DATE: 20/12/23

HYBRID PLANNING APPLICATIONS FOR LAND SOUTH OF BARUGH GREEN ROAD, BARNSELY (2021/1089 for the employment element and 2021/1090 for the residential element)

Many thanks for consulting Yorkshire Wildlife Trust regarding this hybrid application. Due to the large amount of documentation our comments are restricted to the Ecology Chapter of the Environmental Statement (ES) and the Biodiversity Net Gain (BNG) information. We are supportive of the LPA Ecology Team comments on these and other documents, including the BEMP, particularly with regard to the need to manage the retained ancient woodland and retained hedgerows on site.

MAIN INFRASTRUCTURE DRAINAGE STRATEGY SHEET 1

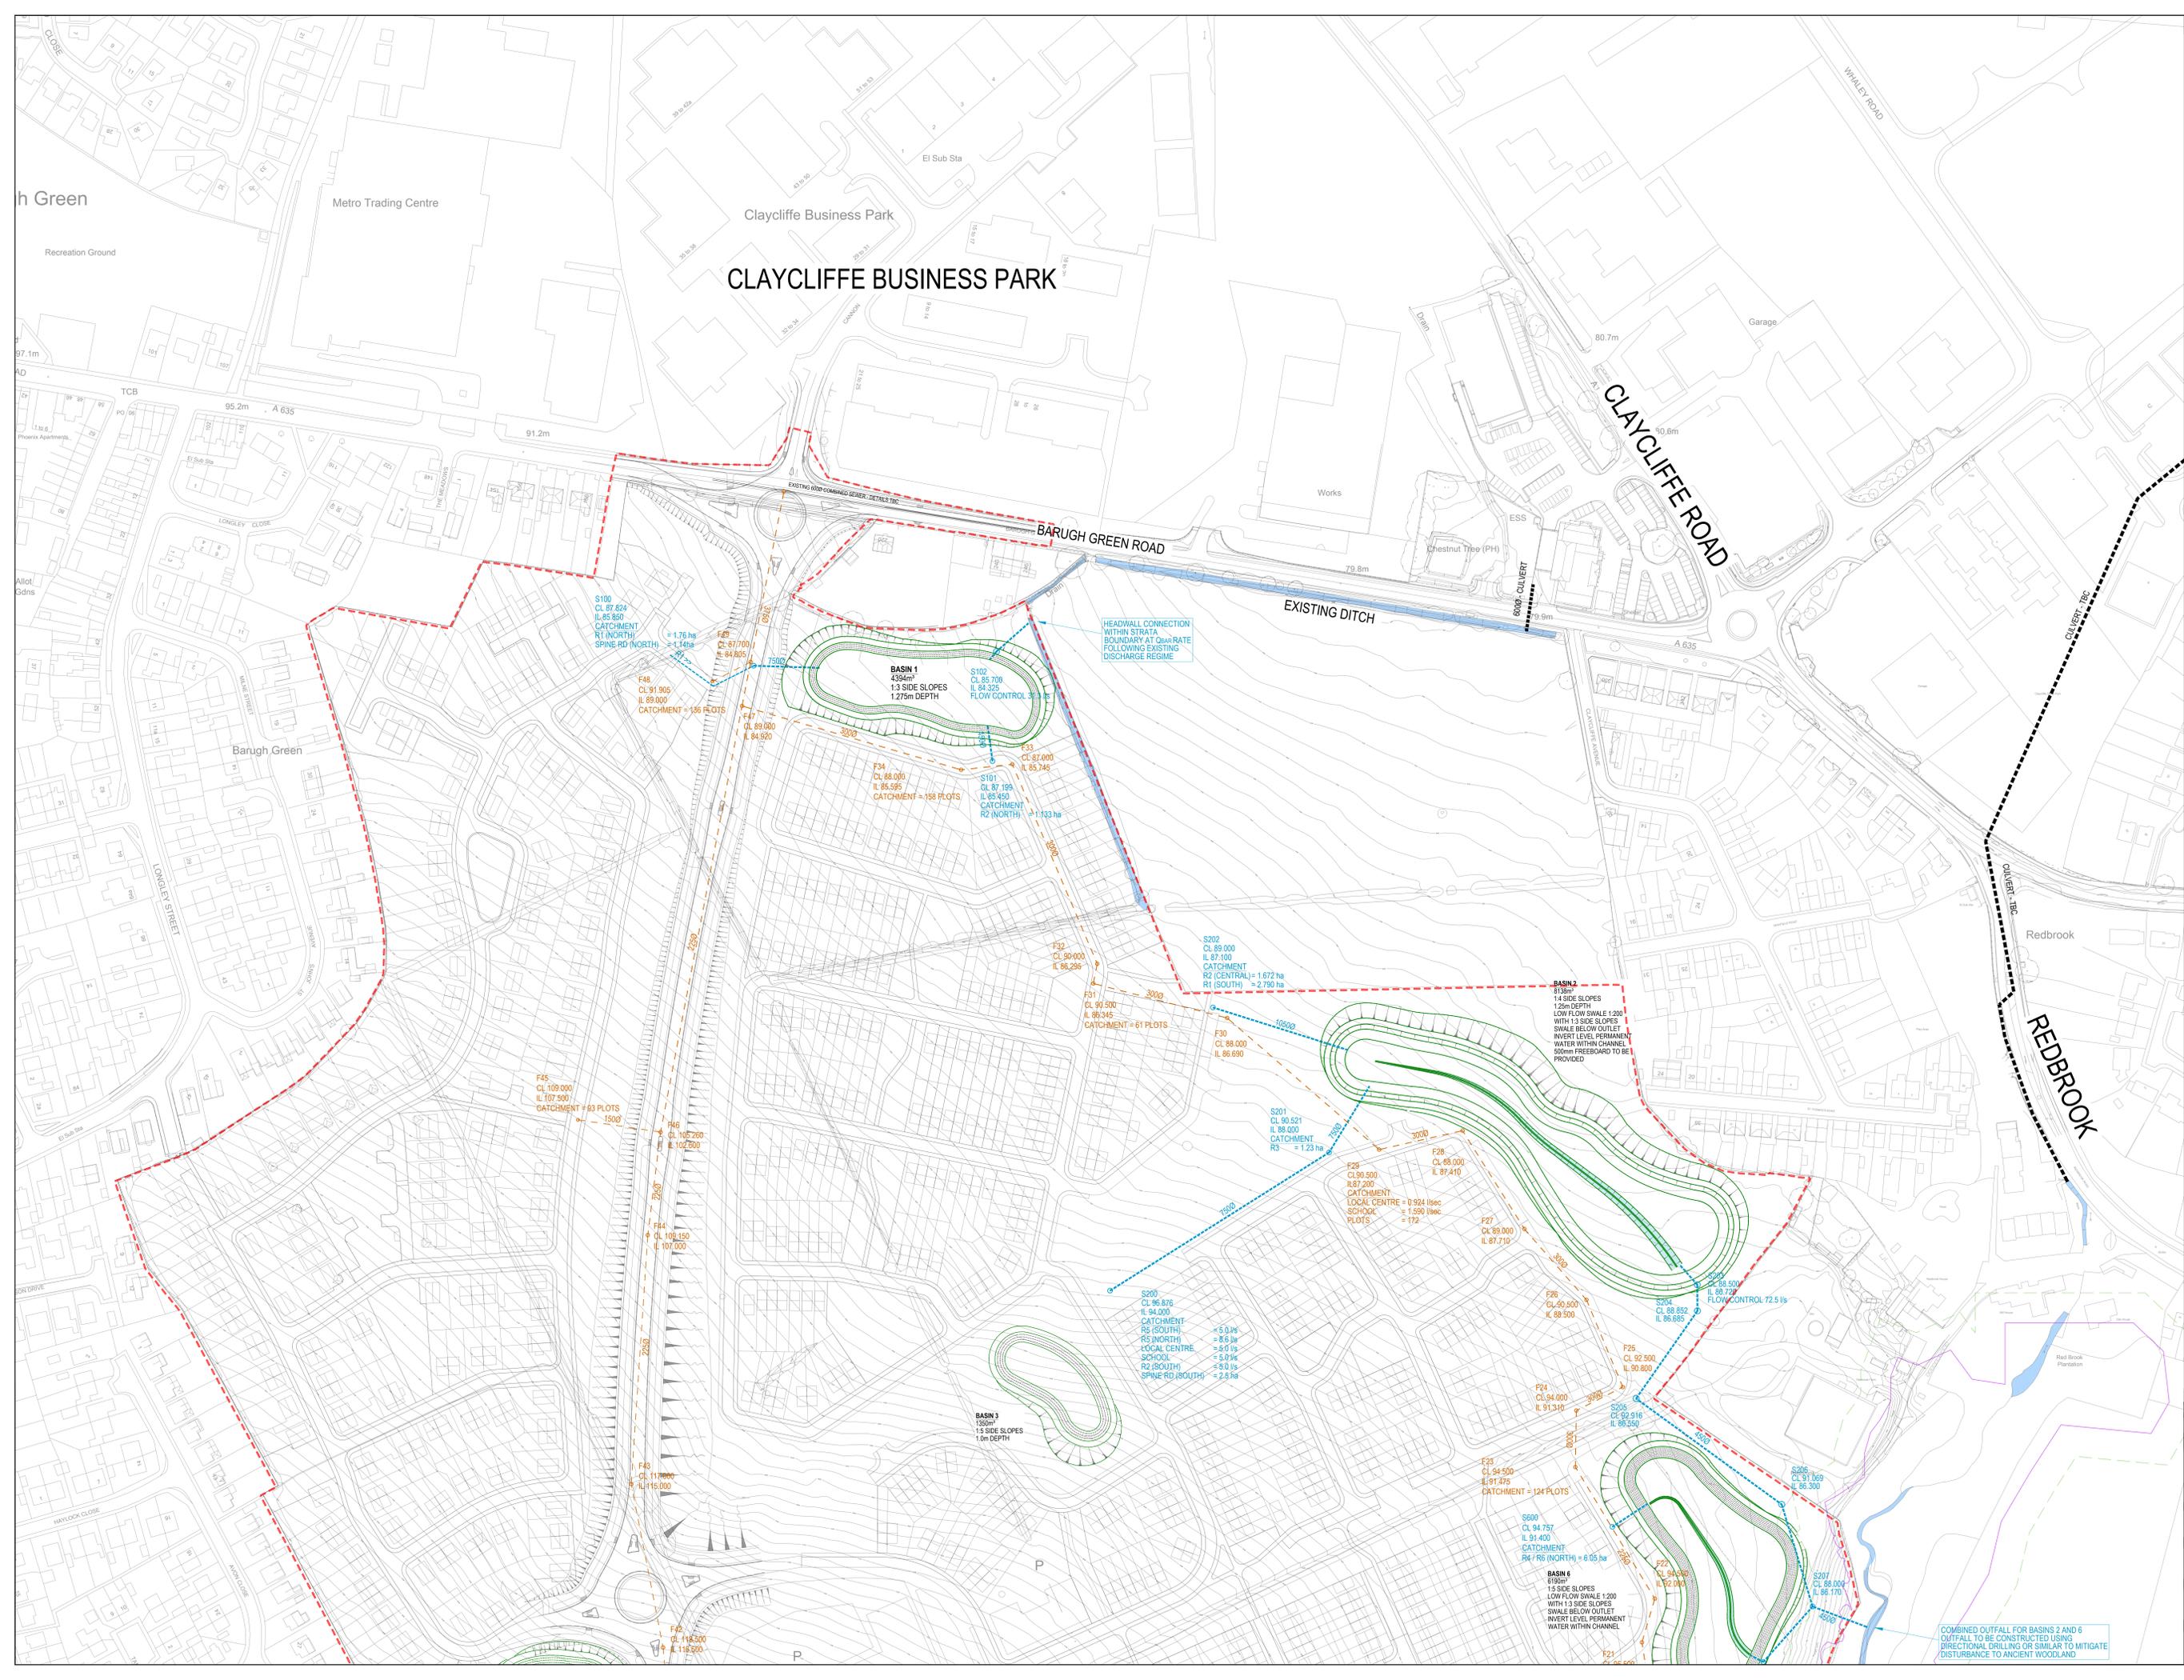
More information is required on the proposed bioswales, and whether these features will provide the same ecological function as the ditches lost – for example the ditch banks which may be absent from a bioswale could provide habitat for species such as water vole. Will the bioswales hold water all year, will they support aquatic vegetation etc?

The ES states that '*a small section of the stream located within the woodland areas to the north of Hermit Lane is likely to be culverted, to facilitate the creation of a development platform*'. It is our understanding that the Environment Agency generally opposes the culverting of watercourses due to adverse ecological and flood defence effects. This is also not in accordance with the MU1 allocation policy which states that the development should '*Retain, buffer and manage the watercourse, grassland and woodland north-east of Hermit Lane*'

Evidence should be provided that all alternatives to this have been exhausted. Should culverting be accepted as the only option, continuity of bankside vegetation is essential.

With reference to the culverting proposals discussed above, confirmation that impacts to the woodland habitat as a result of this culverting proposal have been considered is also required. Does this woodland form part of the ancient woodland complex which has been described? We would strongly object to any impact to ancient woodland due to its status as irreplaceable habitat.
